Approval of reserved matters following outline consent WA/26/18/OUT for layout & scale for 6 No. dwellings & 6 No. detached garages.

Lanes End West Walberton Lane Walberton

Thank you for your internet representation made on 14th March 2019 which has been recorded as '**an objection**' with the comments as follows:

PJ DEVELOPMENTS LTD 2 Square Chambers 23 High Street Emsworth PO10 7AQ Tel: 0843 289 3430 Email: enquiries@pjdevelopmentsltd.com	
PROJECT: FORMER LANES END	
SITE PLAN OUTLINE PLANNING APPLICATION	
DATE: JANUARY 2019	DWG. NO 19-001 PL02
SCALE @ A1: 1:200	
REV: C

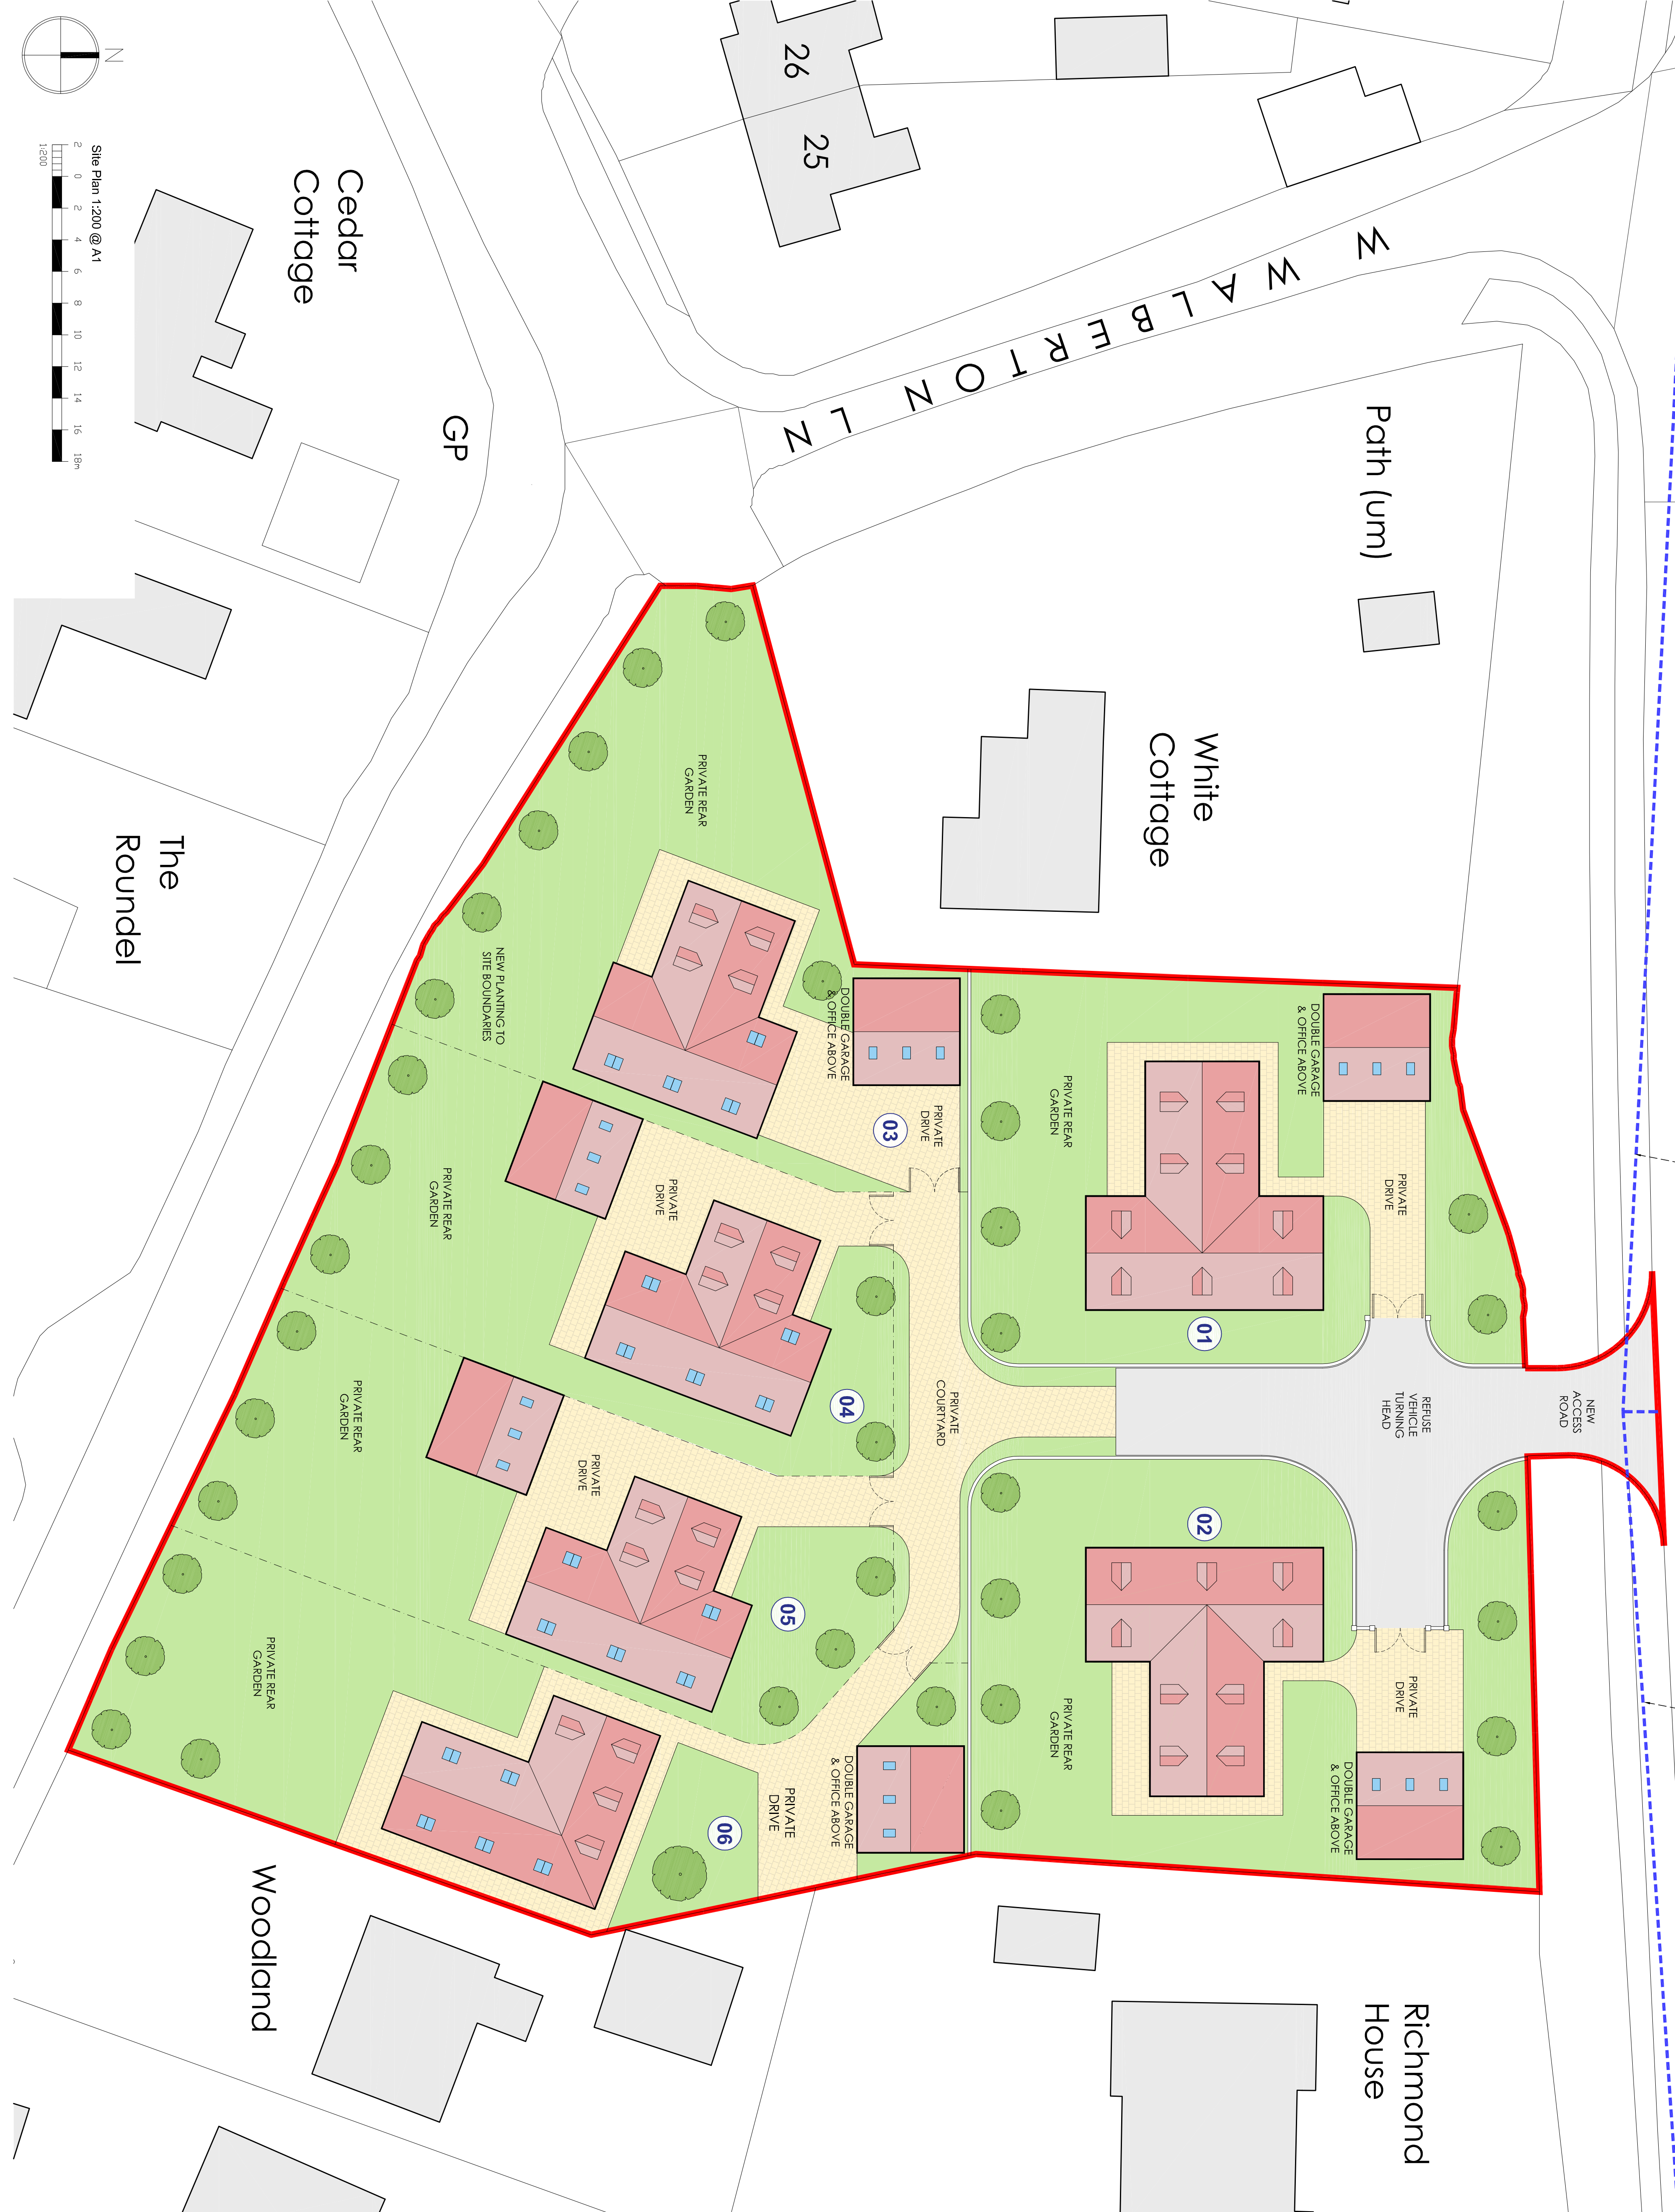
2 It would be beneficial if the Evergreen hedge/trees adjacent to W>W>L could be preserved in some way to help the new properties blend in with the Rural ambience of the lane

3 On the original Outline application the garages were not shown this now makes this over developed site even closer to W>W>L should this know be subject to a fresh application ?

PLOTS 1 AND 2 FLOOR PLANS AND ELEVATIONS

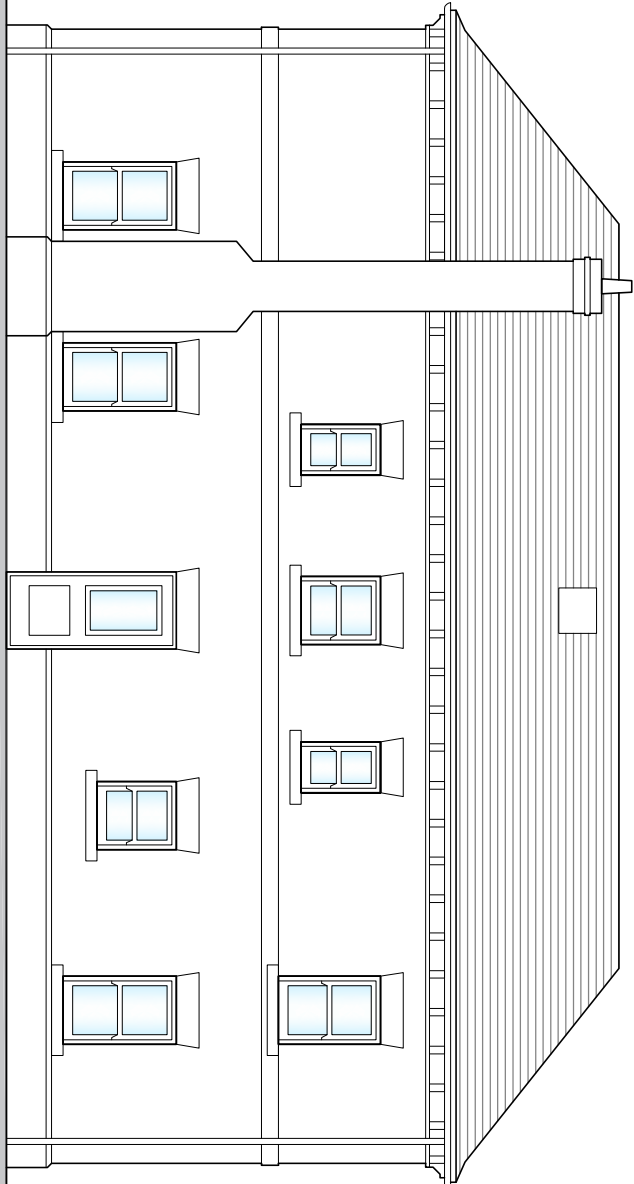
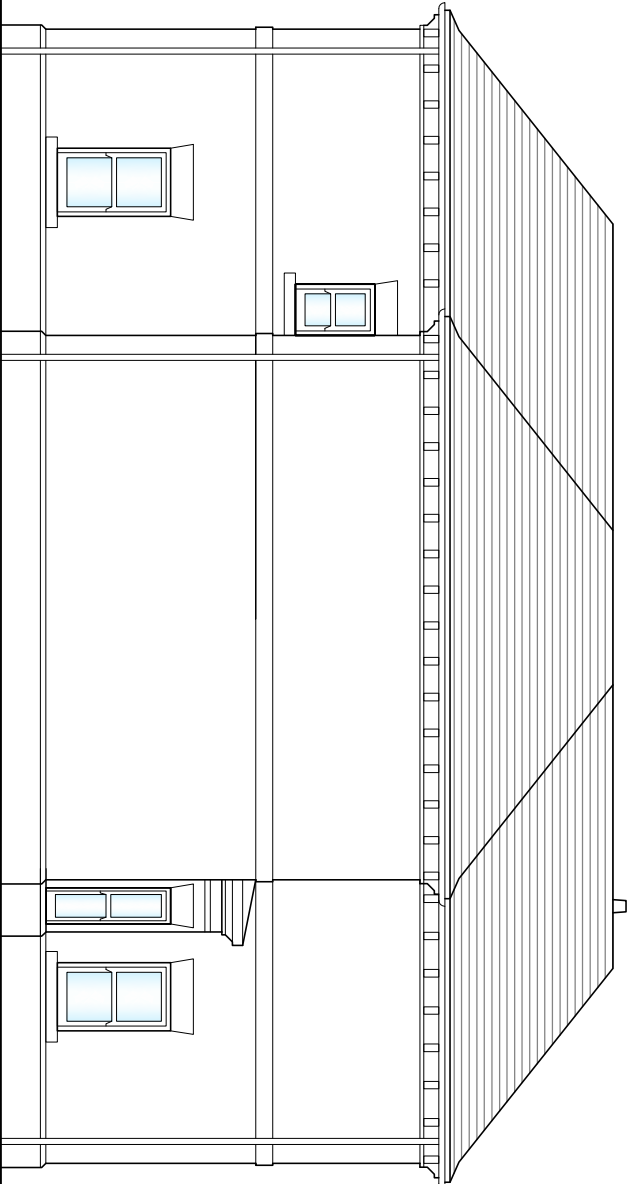
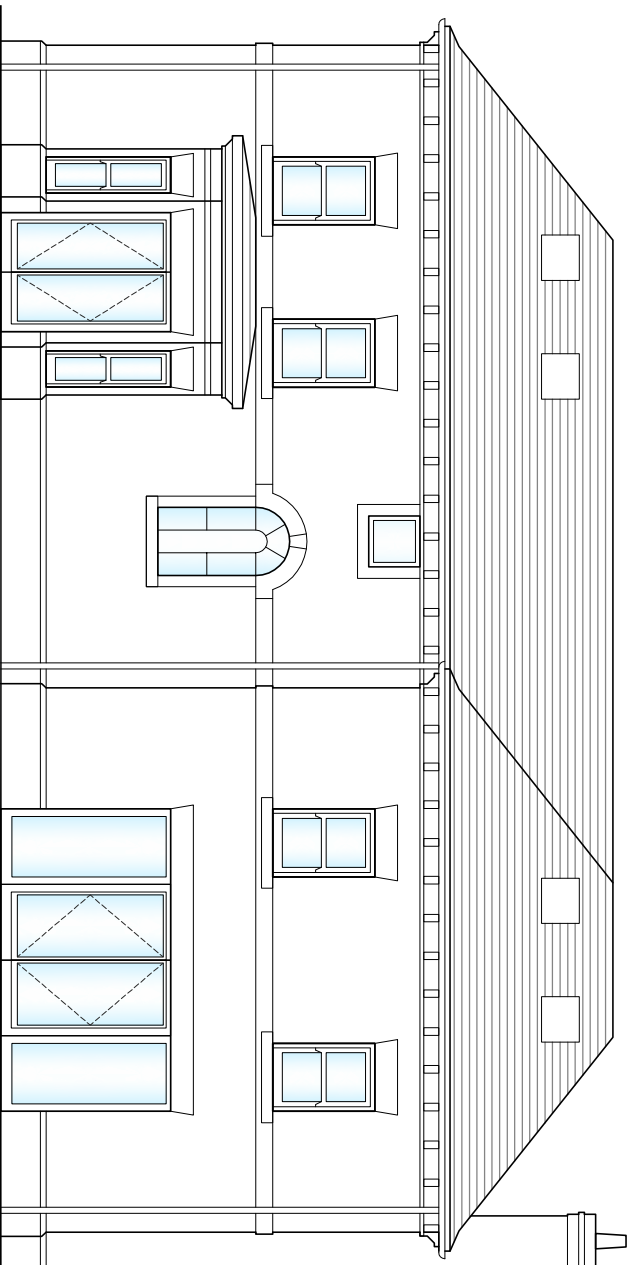
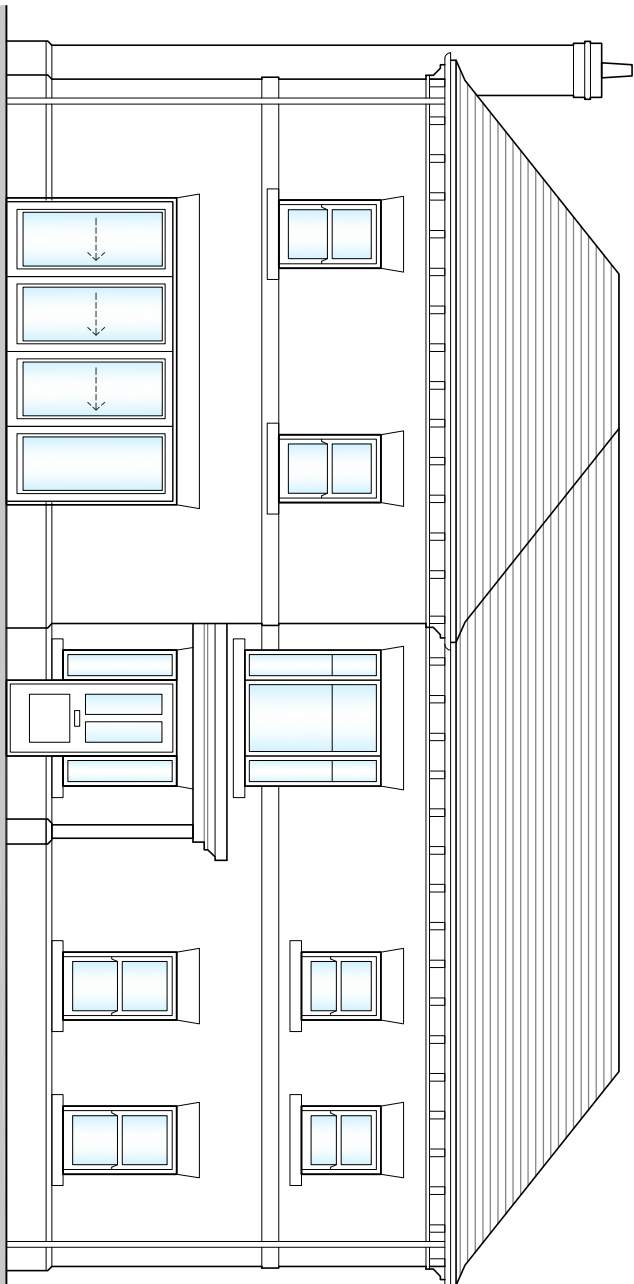
1 The ridge height has to be carefully taken into consideration as the plot rises up considerably from West Walberton Lane thus making the 3 storey houses over powering on the "Street Scene "
